DOC13/431362

Submission on Stage 1 Project Application for Northern Beaches Hospital – Concept Design, Site Clearances and Preparatory Works

Tony McCabe
Director, Planning and Delivery

Figure 9: Indicative NBH Envelope and Site Layout Reference Design – north western view

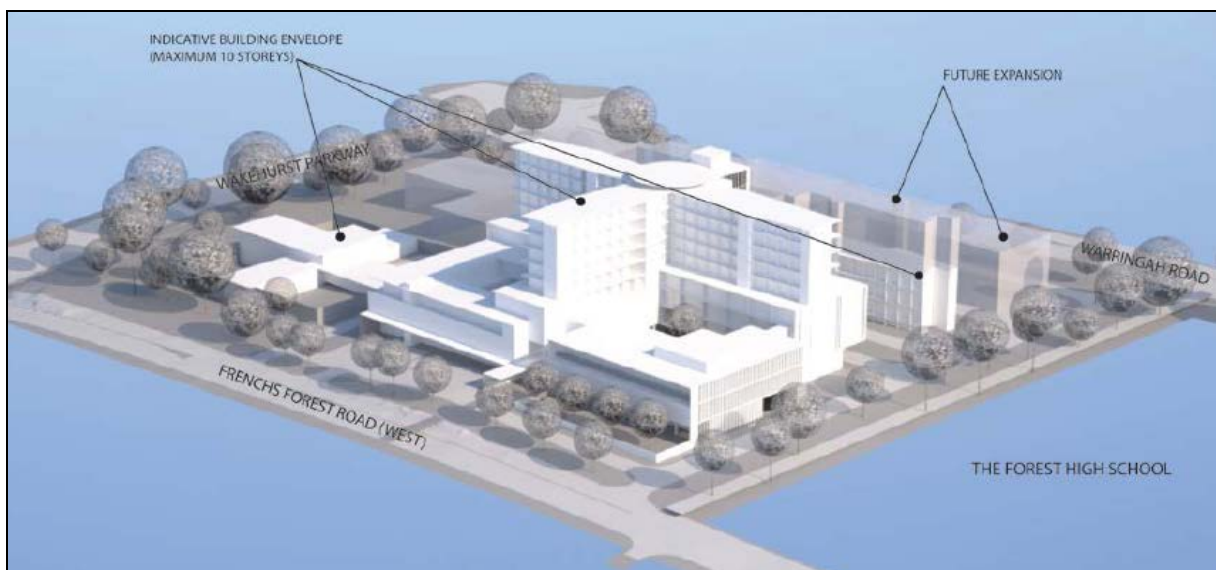
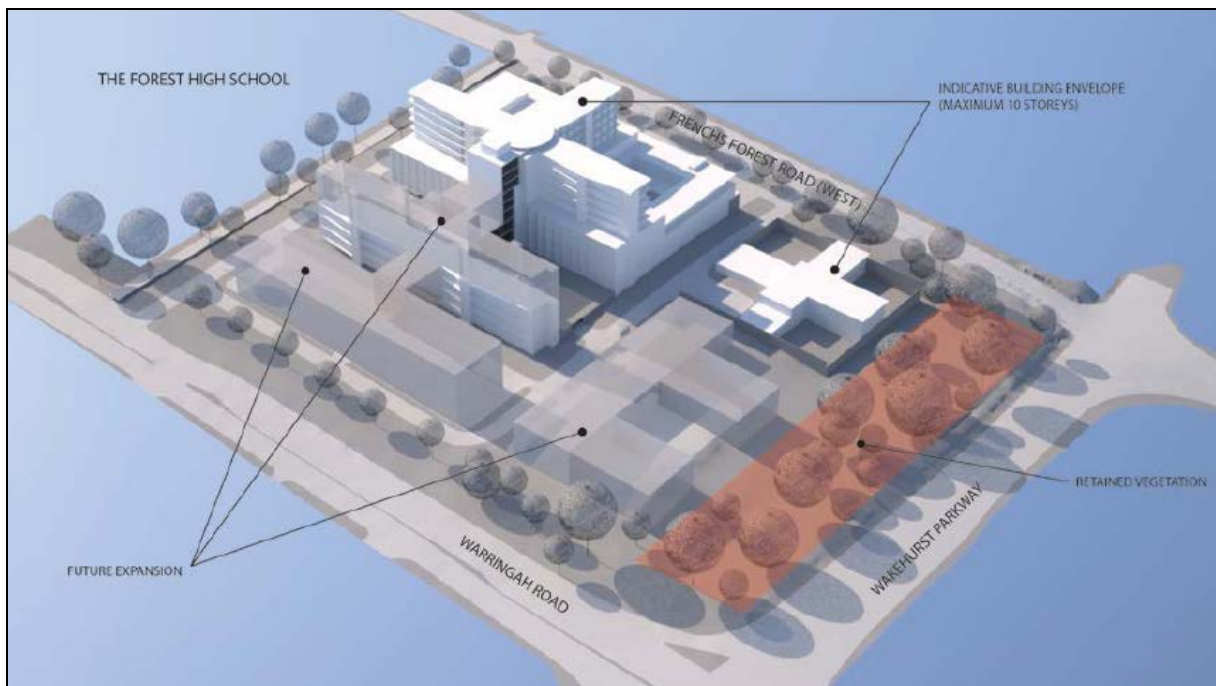
Given the likely scale of the eventual development, the design parameters should be conditioned in the consent for Stage 1 rather than leave it in the hands of a builder/operator to put forward a design of their choosing with only indicative controls to abide by. For example:

- Minimum building setbacks are conditioned at 12 metres from the Forest High School boundary,
- The maximum height of building(s) should also be conditioned at 10 storeys to protect the Forest High School from undesirable over shadowing,
- A range of land uses, that create synergies with neighboring properties, should be considered in the types of permissible developments allowed on the site, for example a child care centre or other resource sharing opportunities,
- The location of helipad should be properly assessed and give consideration to noise impacts on the Forest High School.

Figure 12: Construction sectors

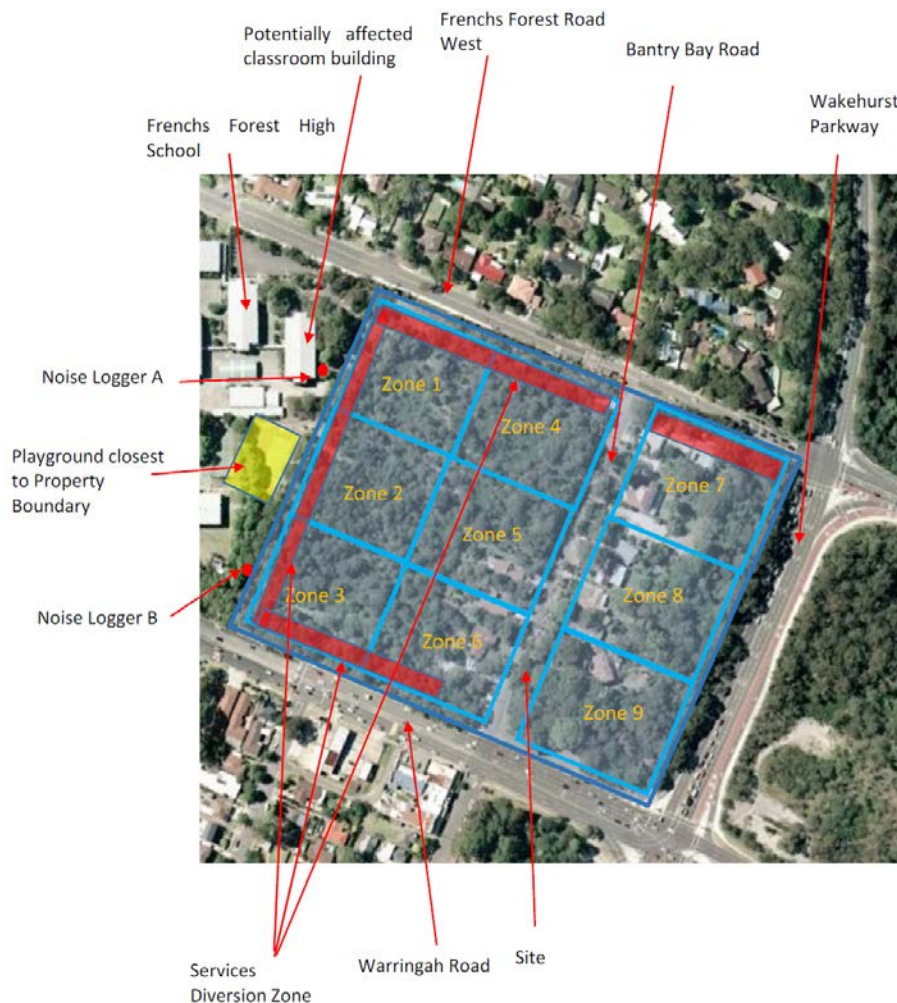
The noise assessment background studies were undertaken during school holidays and may not represent a true noise level. The noise assessment indicates that noise will exceed construction noise criteria for sensitive land uses like schools. This requires noise mitigation measures as only with such measures will students be able learn in the optimum environment, however no such measures have been identified in the EIS.

We therefore request that mitigation measures be implemented, so that students can learn in the optimum environment. This could include:

- Installation of noise barrier walls,
- Glazing of school classroom windows,
- Real time noise monitoring and warning system to management personnel,
- Continued noise monitoring and specific management plans during construction with a communication protocol established with the school,
- Restrictions on construction activities near key areas of the school (e.g. A-Block) during the school day 8:30am to 3:00pm, during certain periods of school activities (e.g. outdoor assemblies) and during exam periods.
